November 21, 2014

**RE: Taos at the Trails Unit 1 Inlet Modification and  
Addendum to Taos Unit 1 Drainage Report for Inlet Modification  
(C09D001C)**

Hydrology has reviewed the structural calculations by Nob Hill Structural Engineering, LLC and the Addendum to the Taos Unit 1 drainage report by Bohannon Huston Inc.

SECTION A-A
NTS

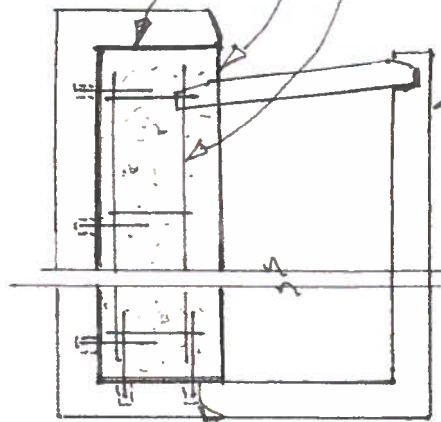
The structural modification Section A-A shows the concrete fill encapsulating a portion of the grate. This would not allow the grate to be removed for maintenance and reduces the capacity of the inlet.

1. Leave the inlet and driveway locations as-is and build a short fence or wall (within zoning criteria) behind the inlet to prevent the homeowner from driving over the curb.
2. Remove the existing inlet (double grate double wing) and construct a new single grate single wing inlet near this location and an additional single grate single wing inlet on the north side of the driveway with a lateral storm drain connecting the two inlets.
